This Response to Submissions Design Report has been prepared by Foster+Partners on behalf of the Pitt Street Developer North Pty Ltd to address the matters raised by government agencies, the public and community organisation groups during public exhibition of the proposed Sydney Metro Pitt Street North Over Station Development (OSD) State Significant Development (**SSD**).

The Department of Planning, Industry and Environment (**DPIE**) issued a letter to the applicant on the 26 August 2020, requesting a response to the comments raised during the public exhibition period for both the Concept SSD DA Modification application (**SSD-8875-Mod-1**) and the Detailed SSD DA (**SSD-10375**).

Maximise solar access to Hyde Park

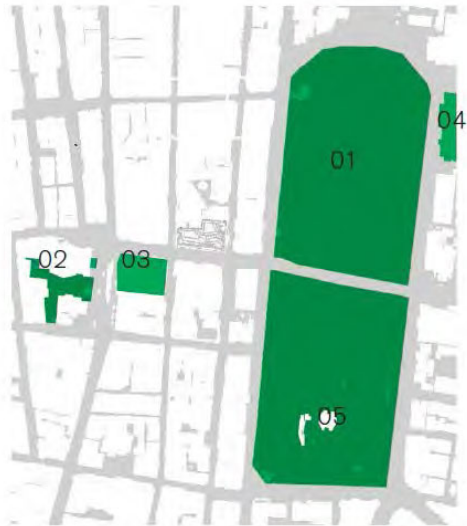
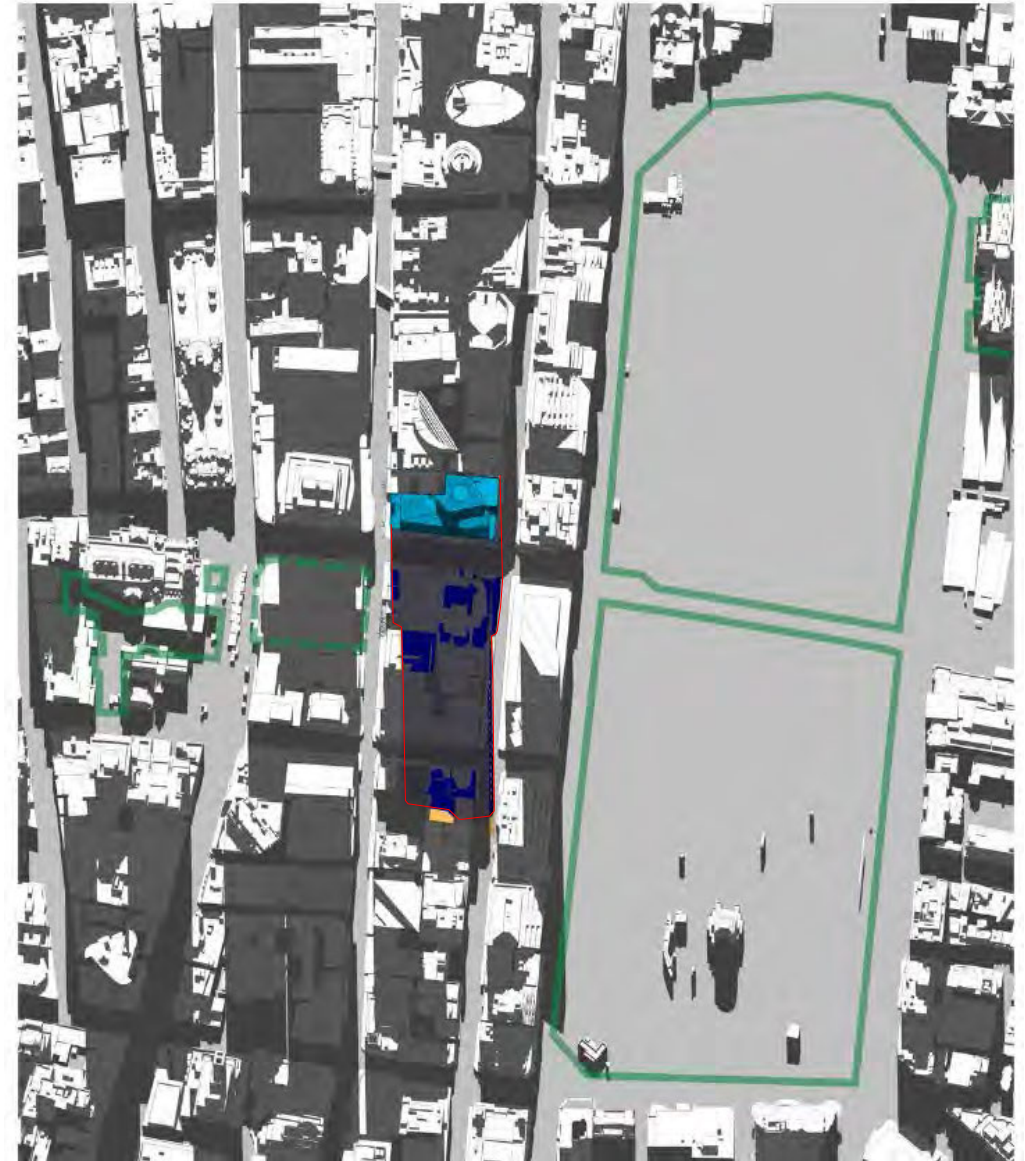
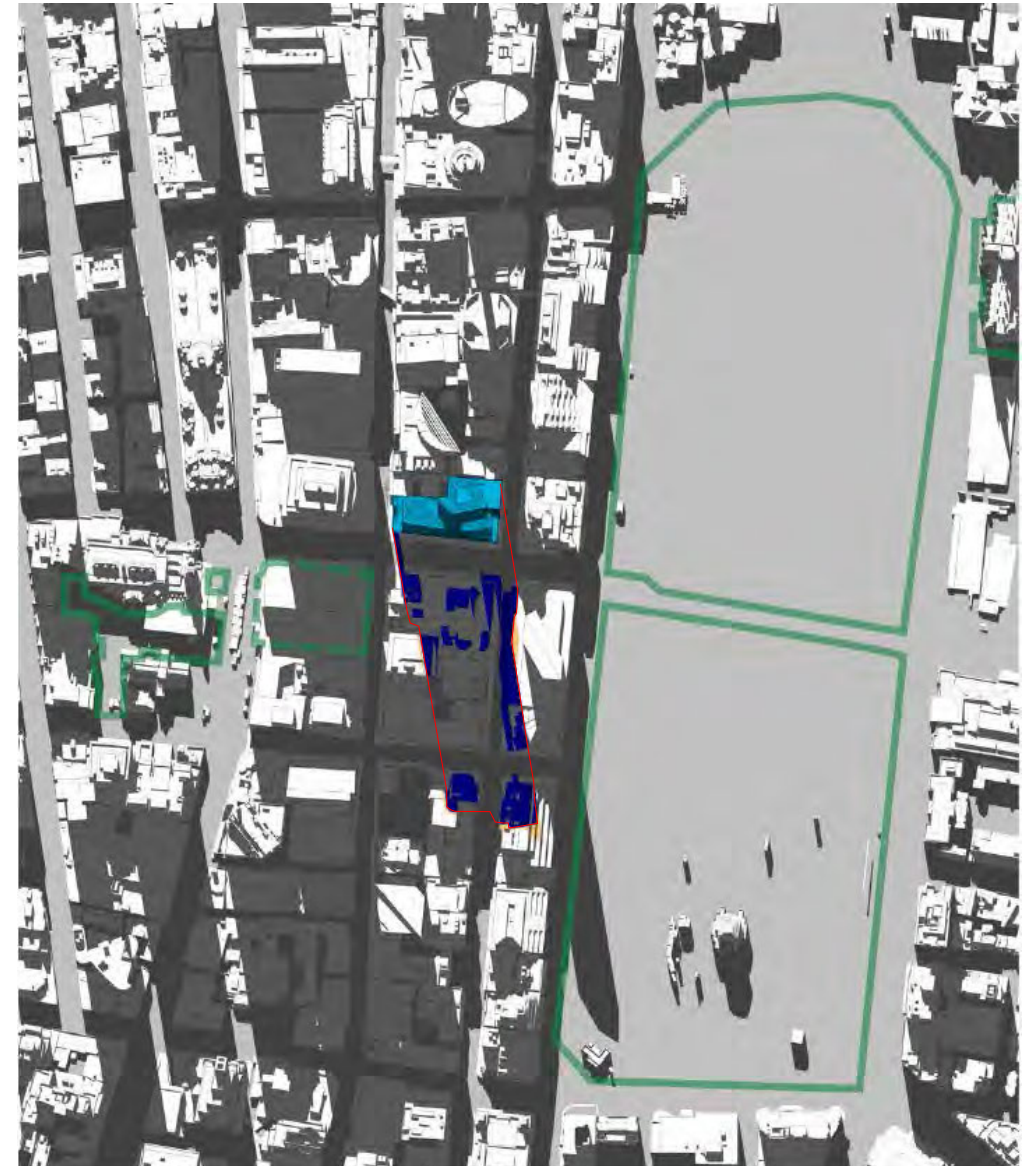
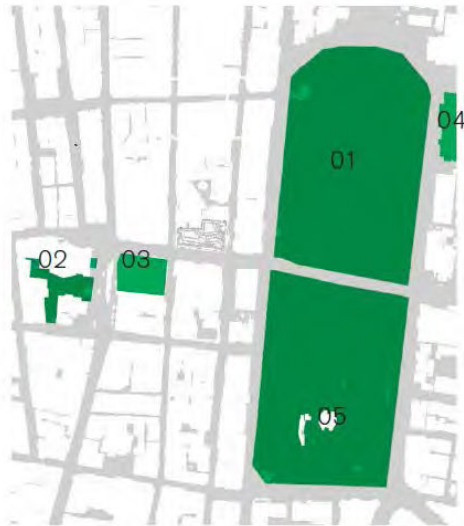
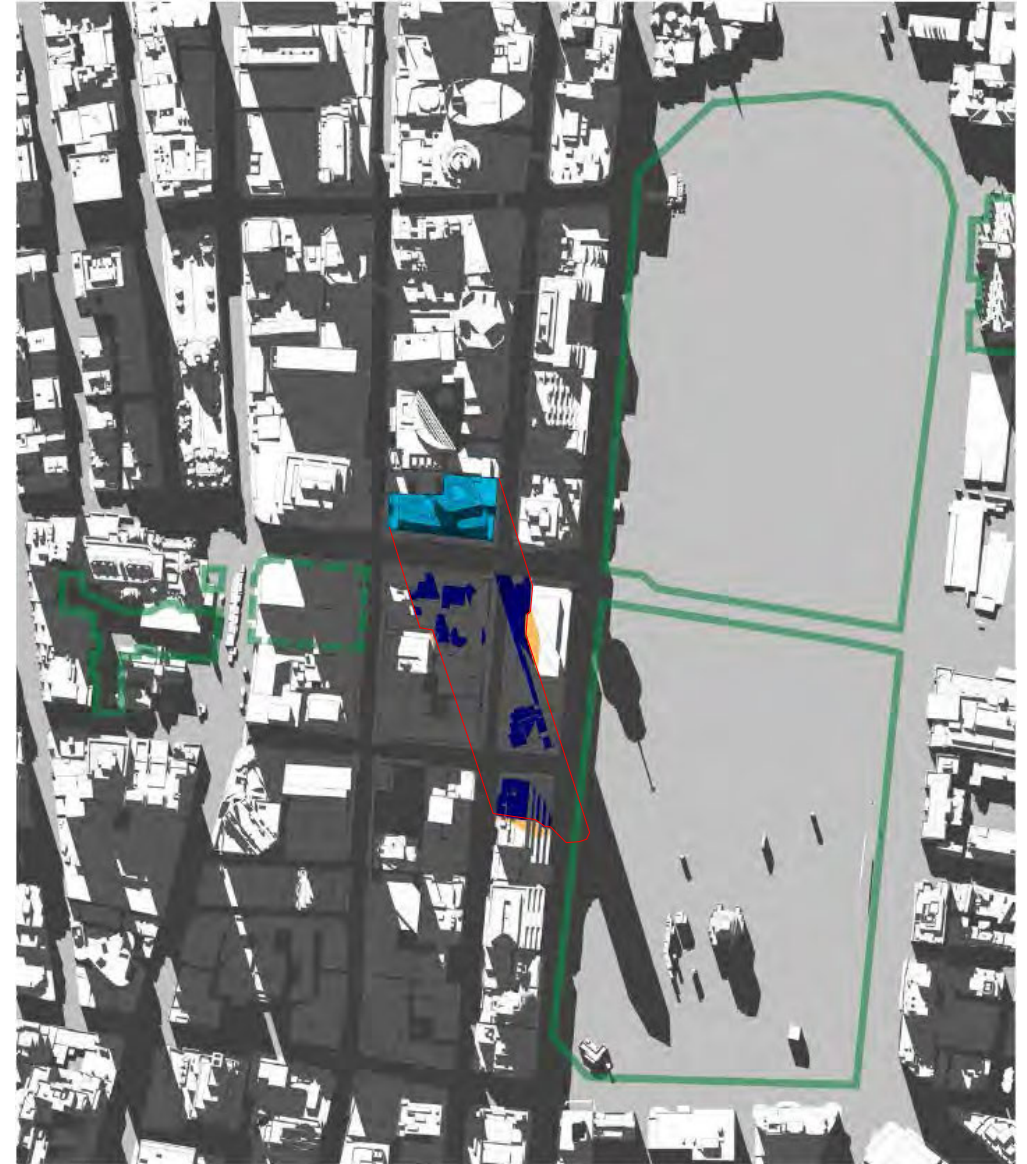
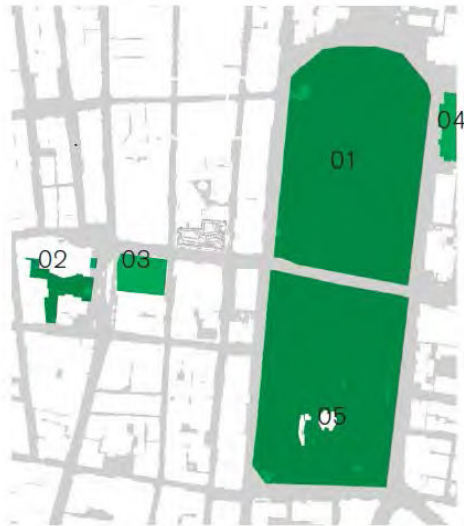
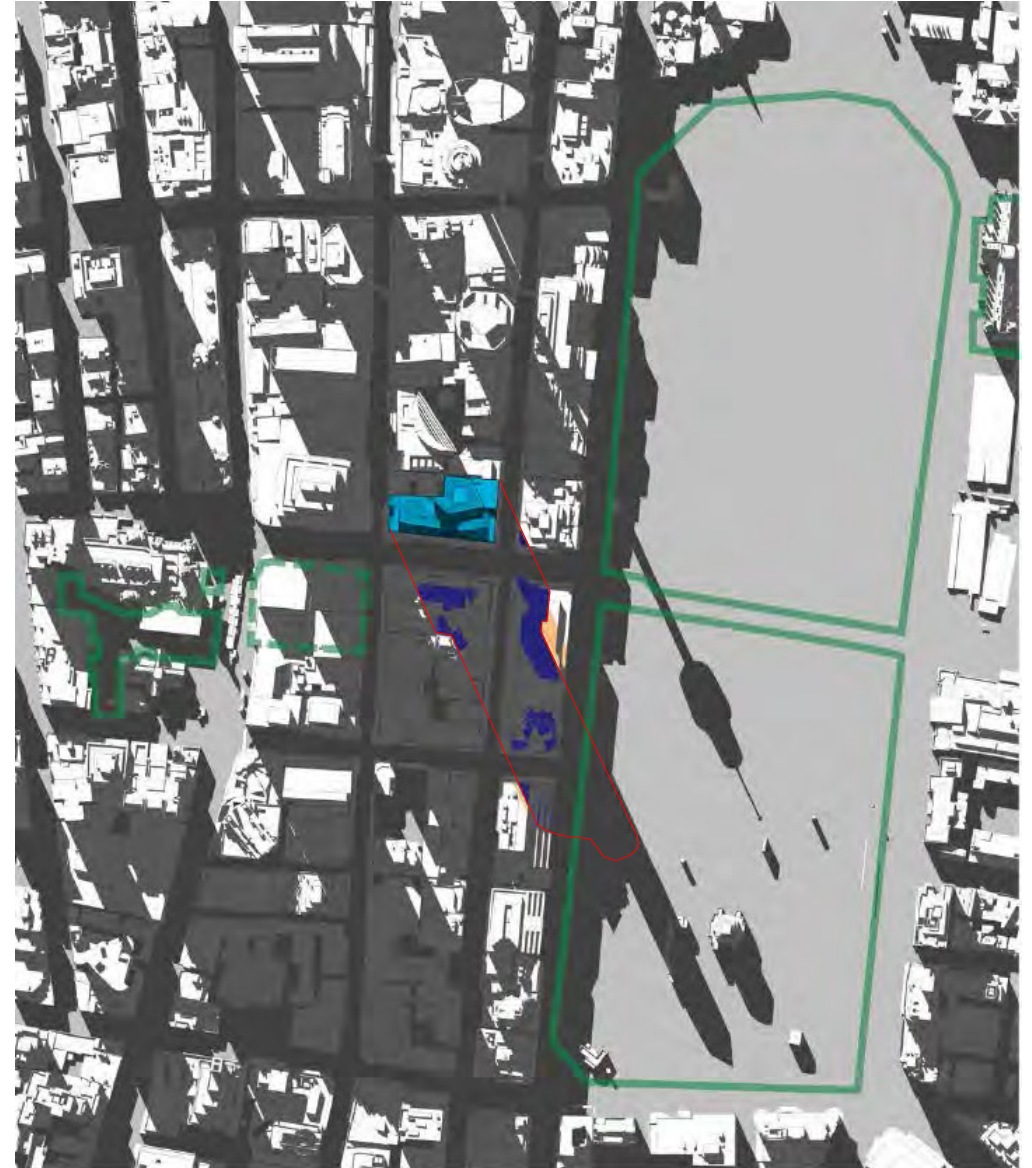
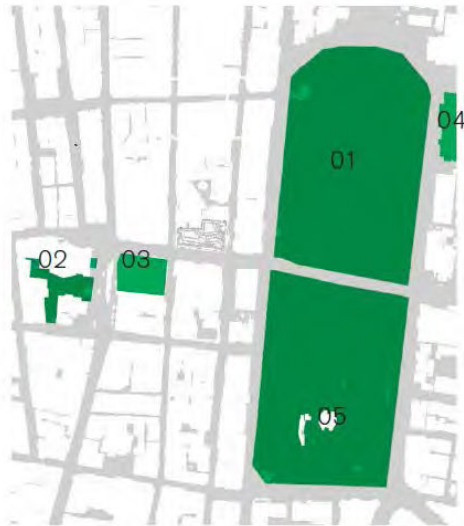
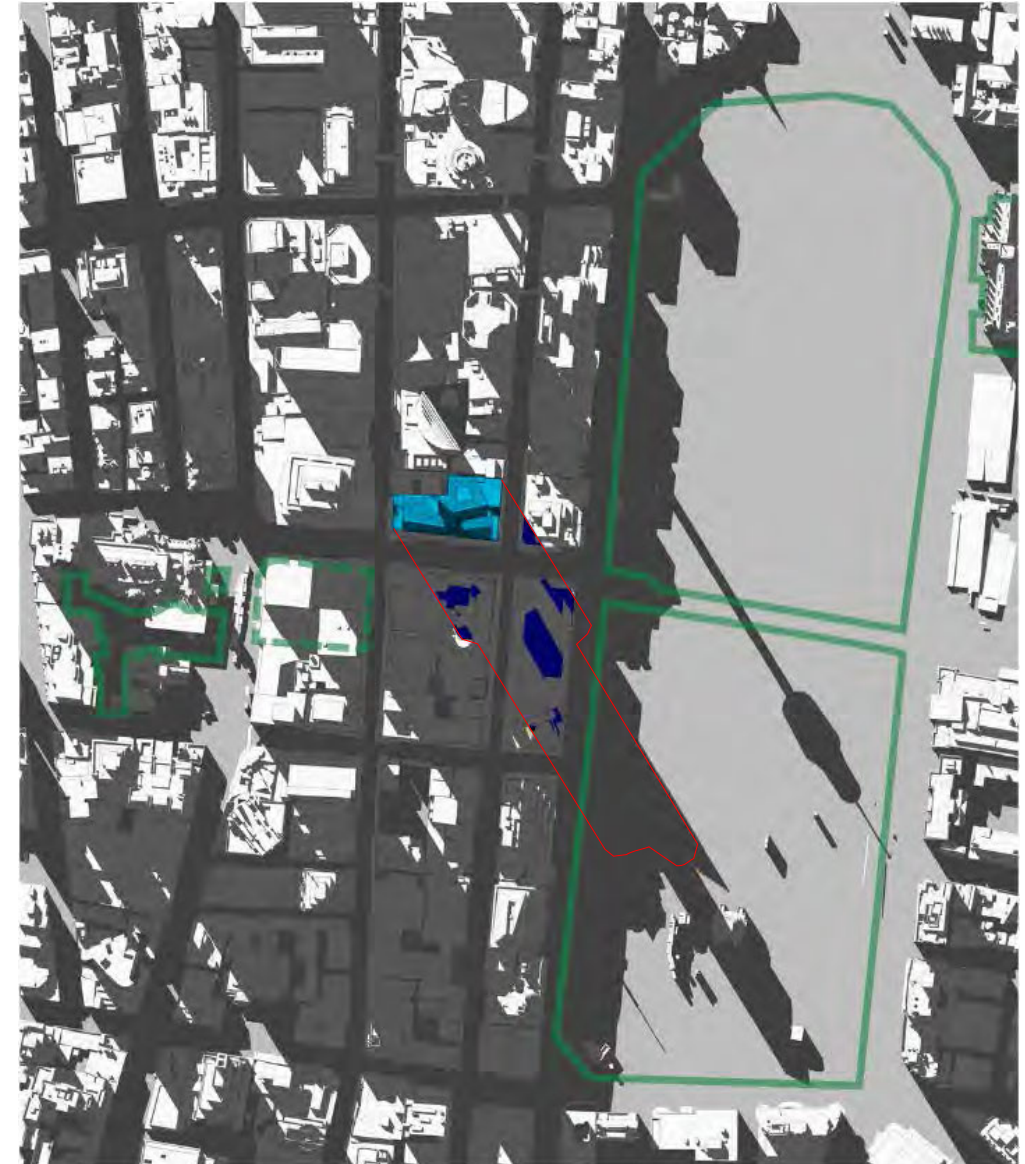
Review the distribution of floor space to minimise external impacts and satisfy the following Design Guidelines requirements:  
(6.b) Maximise solar access to the public domain, through responding to the reduced shadow cast by the redevelopment of 201 Elizabeth Street on Hyde Park on June 21st, between 12pm and 2pm -Sydney Metro preliminary design work propose an angled offset of the north eastern corner of 4.1m to achieve this outcome.

With the Solar Access Plane established as an offset of 4.1m from the original SEARs envelope, the facade outline to this North-Eastern corner of the development has been further set back an additional 550mm from the Solar Access Plane.  
The front edge of the expressed horizontal sunhoods is set off 50mm from this same Solar Access Plane as indicated on the sectional diagram on this page.  
The following pages show compliance with the requirement of no additional overshadowing to Hyde Park on June 21st between the hours of 12pm to 2pm when shown in light of the approved Concept Envelope on 201 Elizabeth Street.
